Comment for planning application 20/01747/F

Application Number	20/01747/F
Location	Land South Side Of Widnell Lane Piddington
Proposal	Change of Use of land to a 6no pitch Gypsy and Traveller site to include 6no mobiles, 6no tourers and associated operational development including hardstanding and fencing
Case Officer	Matthew Chadwick
Organisation Name	I Dodson
Address	3 Drinkwater Close,Piddington
Type of Comment	Objection
Type	neighbour
Comments	<p>See PDF file attached to object to this application. I have carefully read the above application which should be considered in conjunction with (i) a current application 20/01122/F, and two refused applications (ii) 17/001145/F and (iii) 17/01962/F. Please note that TWO similar applications have been REFUSED by Cherwell (17/001145/F, and 17/01962/F) and the smaller development of 6 pitches only scraped through on appeal if certain strict conditions were met by the applicant (see APP/C3105/W/18/3209349) none of which appears to have been implemented. With all these different applications on the same field, it seems as though Cherwell DC is being taken advantage of, in that there appears to be no coherent plan for Travellers in the Dist

# Proposed Block Plan

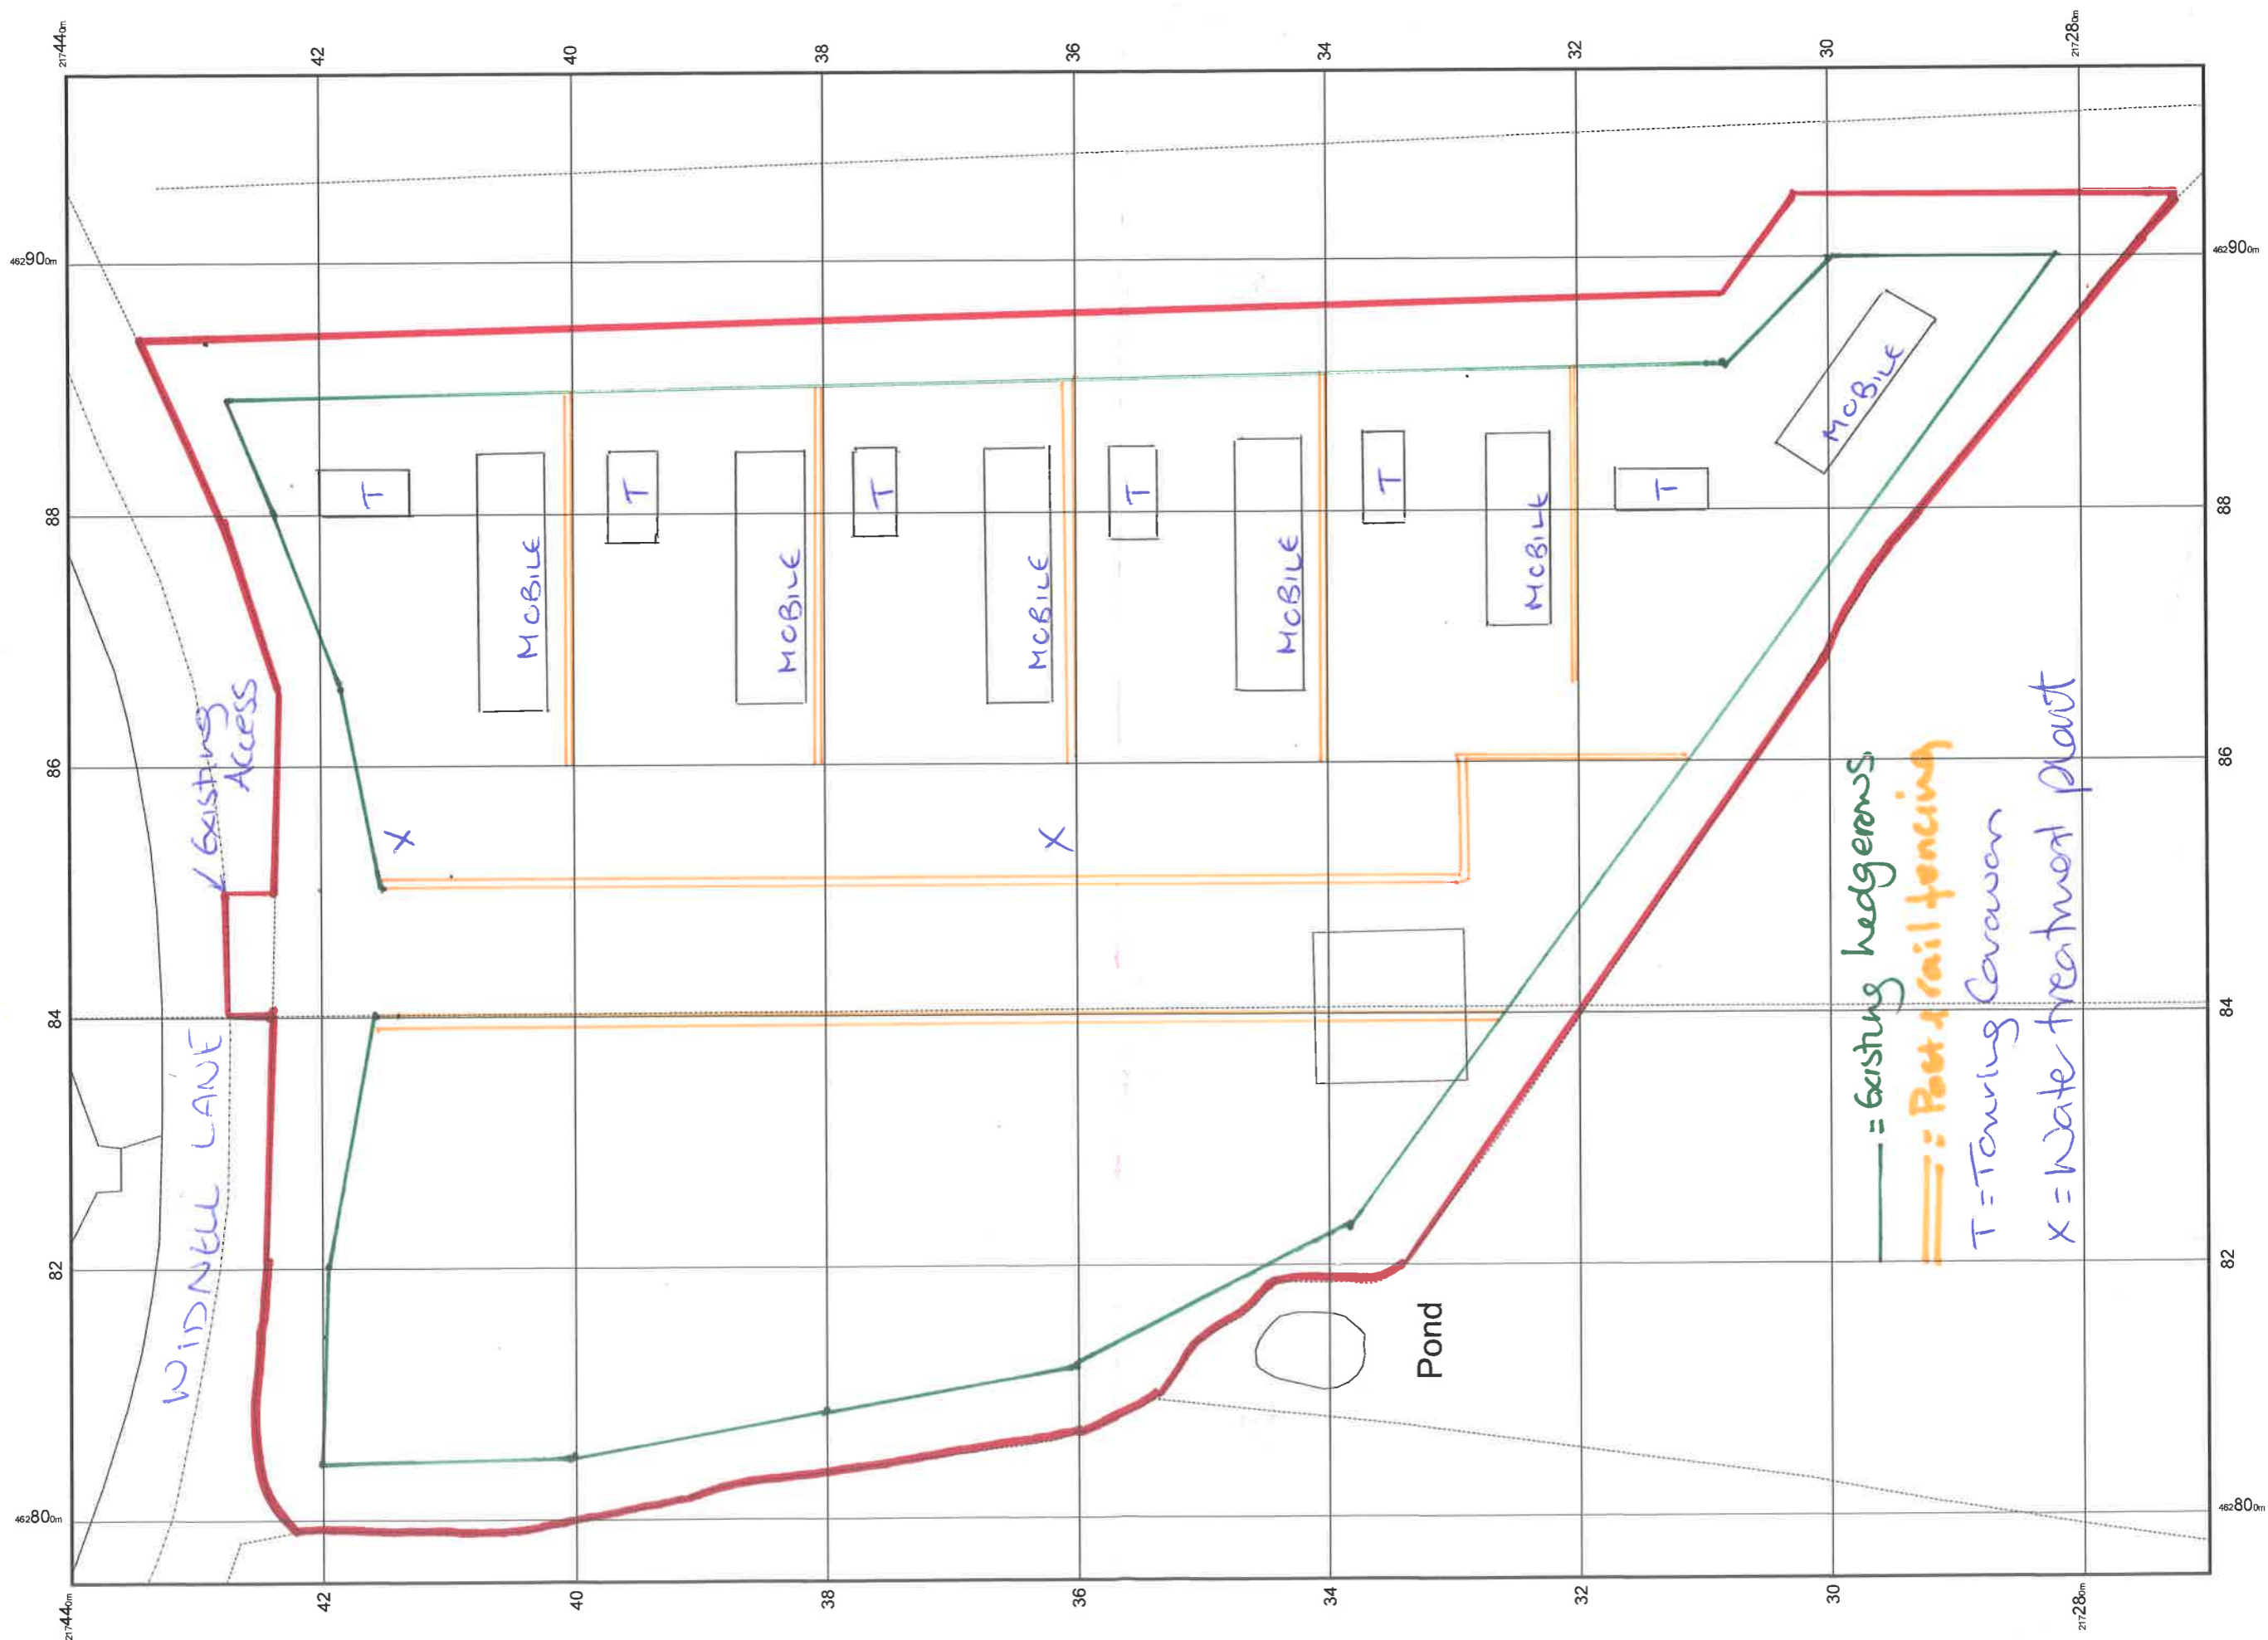
The Block Plan submitted identifies an 'Existing Entrance' for application 20/01747/F. Please note that there is NO EXISTING ENTRANCE onto Widnell Lane from this parcel of land. The only entrance is on the land associated with the active application 20/01122/F.
